YorkshireWater

Your Ref: 2026/90232

Our Ref: B/01084

New Mills, Brougham Road, Marsden, Huddersfield – (KIRK) Redevelopment of mill complex of 11,584sqm for mixed use development, including building demolition, site clearance, site remediation works, the removal of buildings and floor slabs to open up the River Colne, repairs to retained buildings, conversion of lower ground floor of western mill to Class E (food and non-food retail, restaurant and cafe), new buildings providing light industrial / R&D uses (limited to Use Classes Eg(ii)(iii)), the alteration and repair of an office building (Use Class Eg(i)), creation of a new public square and associated hard and soft landscaping, circulation and servicing space, car parking and ancillary structures

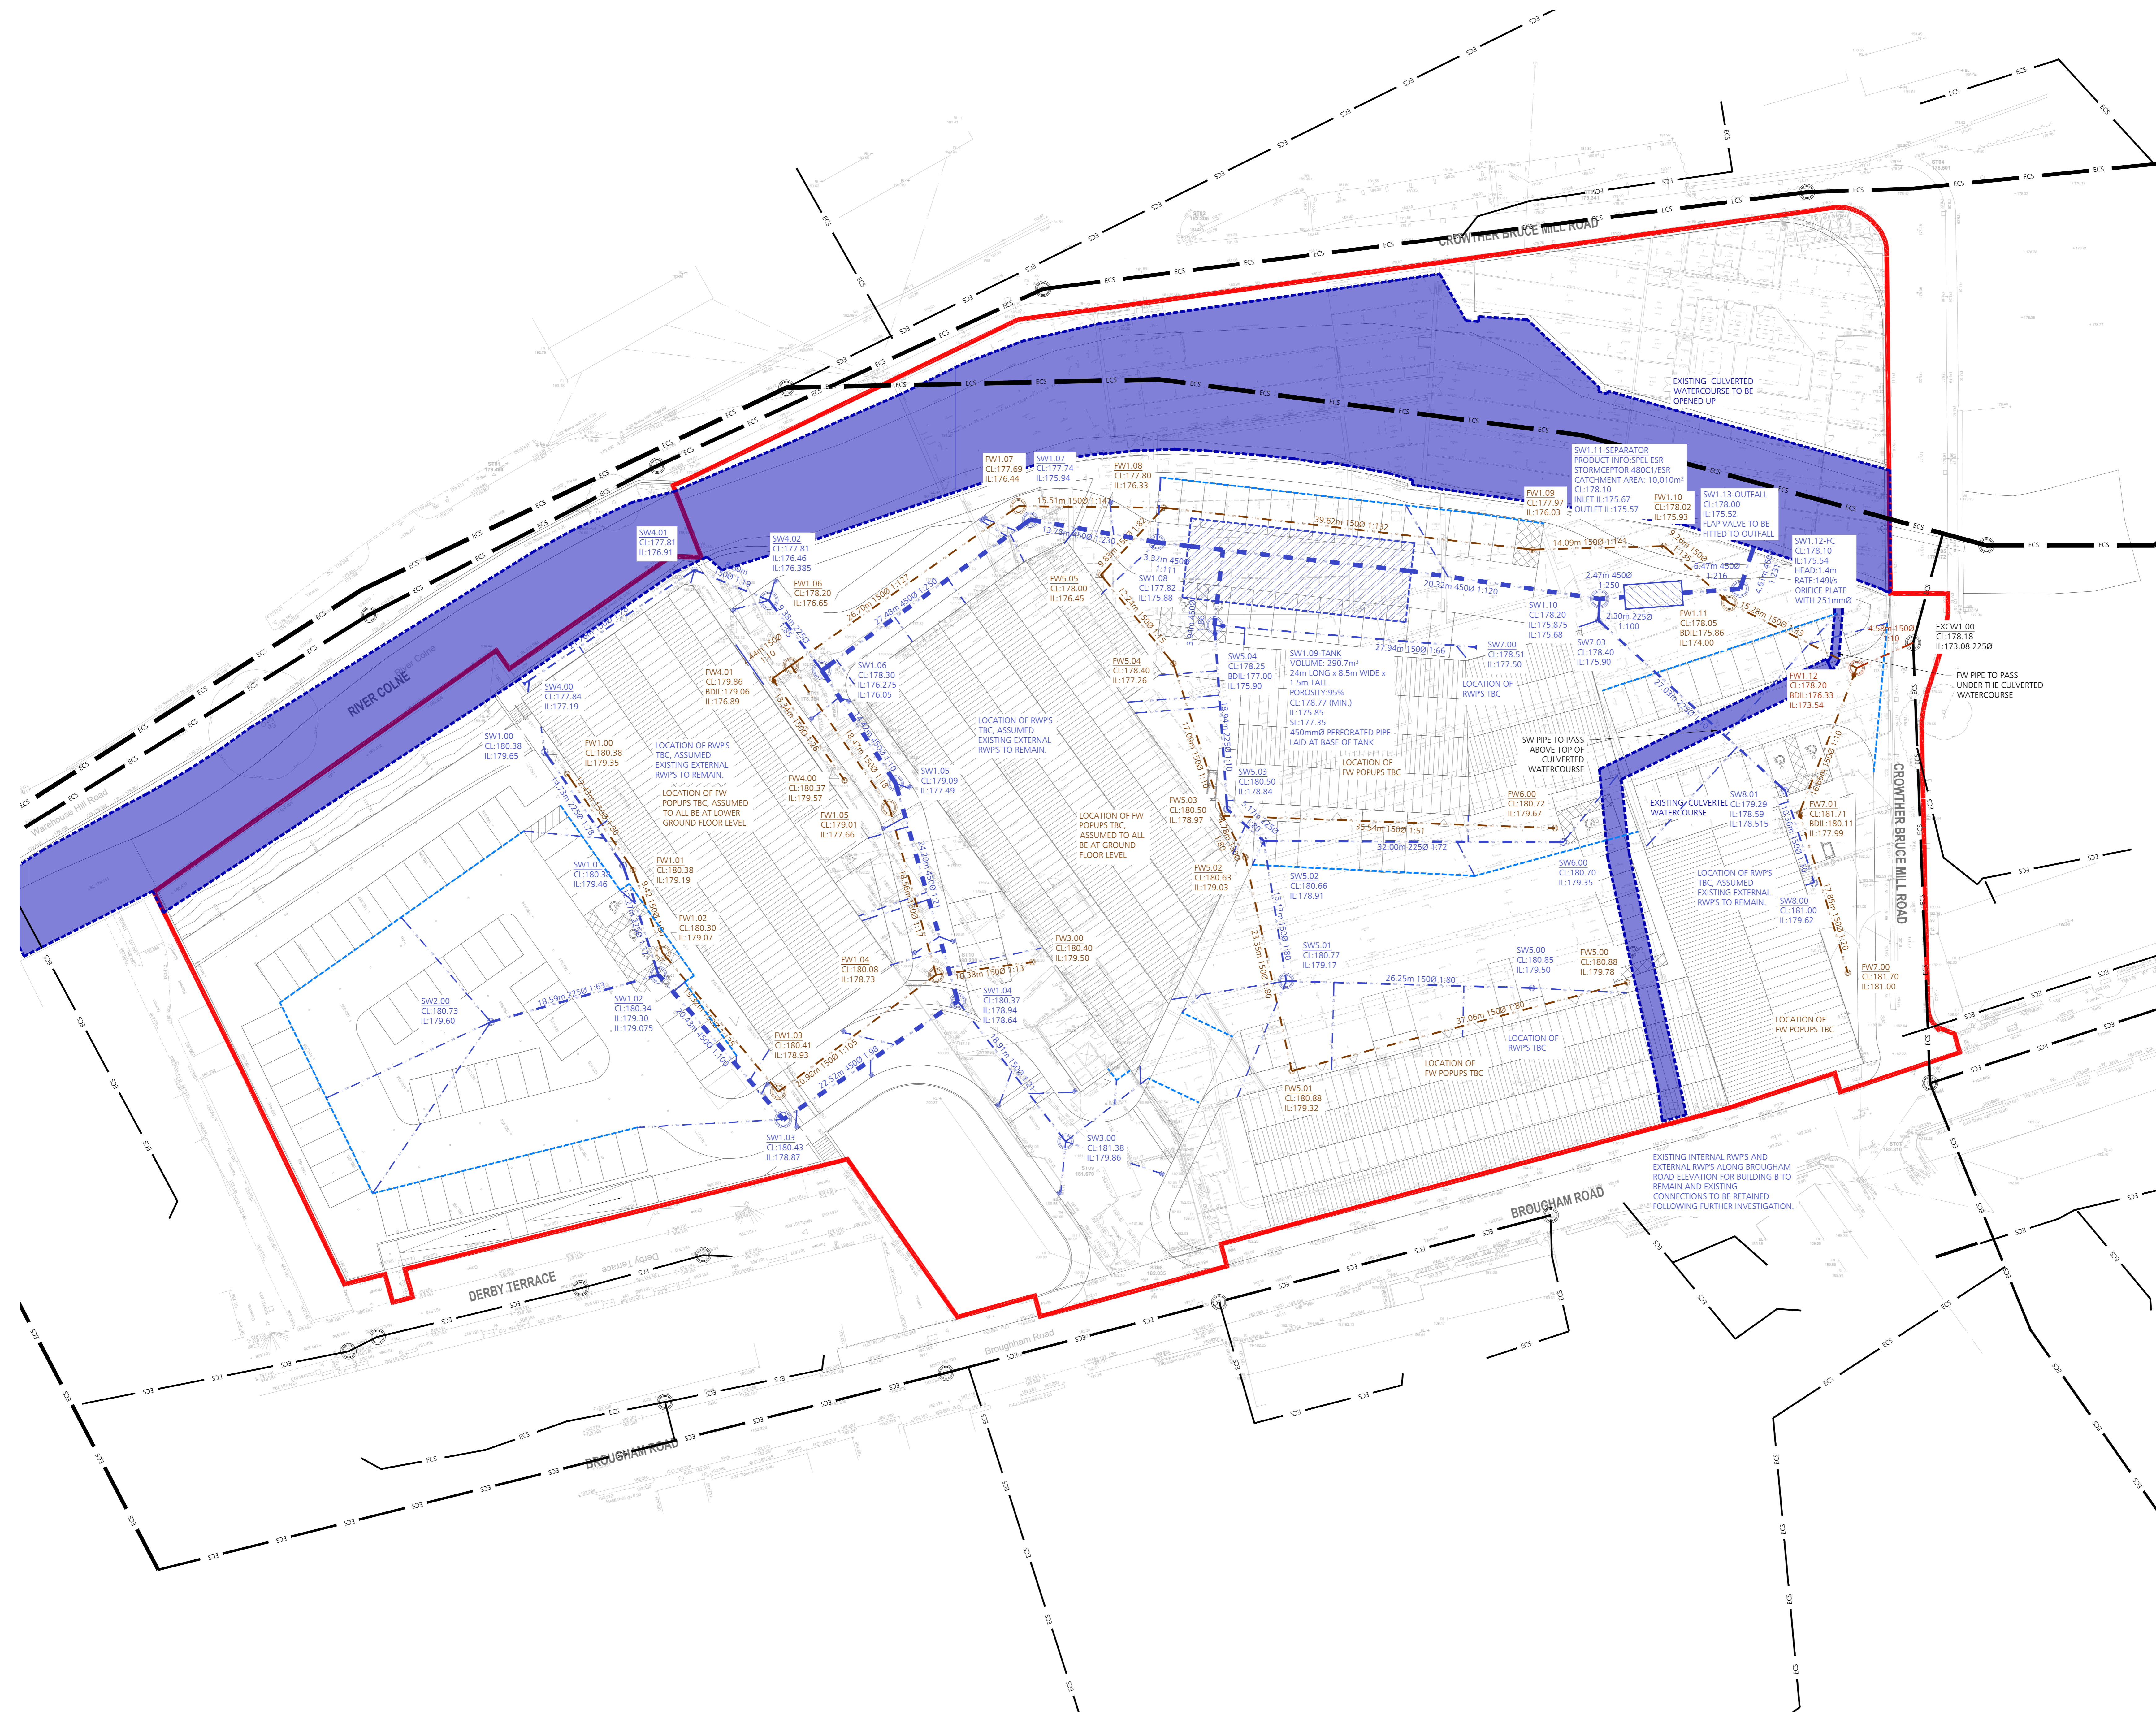
- 1) The proposed separate systems of drainage on site and off site
- 2) The proposed point of discharge of foul water to the public 300/225mm diameter combined sewer in Crowther Bruce Mill Road
- 3) The submitted drawing shows surface water proposed to be drained to watercourse (River Colne) at a maximum rate of 149 litres/second
- 4) The proposed use of a separator

submitted on drawing 23421-DCE-XX-XX-D-C-100 (revision P03) dated 03/12/2025 that has been prepared by Dudleys Consulting Engineers.

On the Statutory Sewer Map, there is a 450 mm diameter public combined sewer recorded to cross the site. It is essential that the presence of this infrastructure is taken into account in the design of the scheme.

- 1) It may not be acceptable to raise or lower ground levels over the sewer and we will not accept any inspection chambers on the sewer to be built over.
- 2) In this instance, a stand-off distance of 4 (four) metres is required at each side of the sewer centre-line and it may not be acceptable to raise or lower ground levels over the sewer, nor to restrict access to the manholes on the sewer.
- 3) A proposal by the developer to alter/divert a public sewer will be subject to Yorkshire

The work listed in the development description includes the removal of buildings and floor slabs to open up the River Colne, the 450mm diameter combined sewer recorded crossing the site appears to run either within or under the culverted section of the River Colne so may be impacted by this work, there is a risk the work may open up a new route of surface water infiltration into the public sewer. Yorkshire Water will require a CCTV survey to determine the exact route and position of the sewer, and remedial work to protect the sewer may be required. The submitted Illustrative Landscape Masterplan (PWP-847-DR-L-0001, revision 02 dated 20/04/2026 and prepared by PWP) details green space and tree planting on both the north and south banks of the River Colne. Yorkshire Water do not allow tree planting within 5 (five) metres either side of public sewers, this is due to the risk of root ingress damaging and potentially blocking the public sewer. We will need to see the site surveyed position of the public sewer with confirmation the proposed tree planting is a minimum 5 metres away from the public sewer.

No building or other obstruction including landscape features shall be located over or within 4 metres either side of the centre line of the public sewer i.e. a protected strip width of 8 metres, that crosses the site. Furthermore, no construction works in the relevant area(s) of the site shall commence until measures to protect the public sewerage infrastructure that is laid within the site boundary have been implemented in full accordance with details that have been submitted to and approved by the Local Planning Authority. The details shall include but not be exclusive to the means of ensuring that access to the pipe for the purposes of repair and maintenance by the statutory undertaker shall be retained at all times. If the required stand-off or protection measures are to be achieved via diversion or closure of the sewer, the developer shall submit evidence to the Local Planning Authority that the diversion or closure has been agreed with the relevant statutory undertaker and that, prior to construction in the affected area, the approved works have been undertaken.
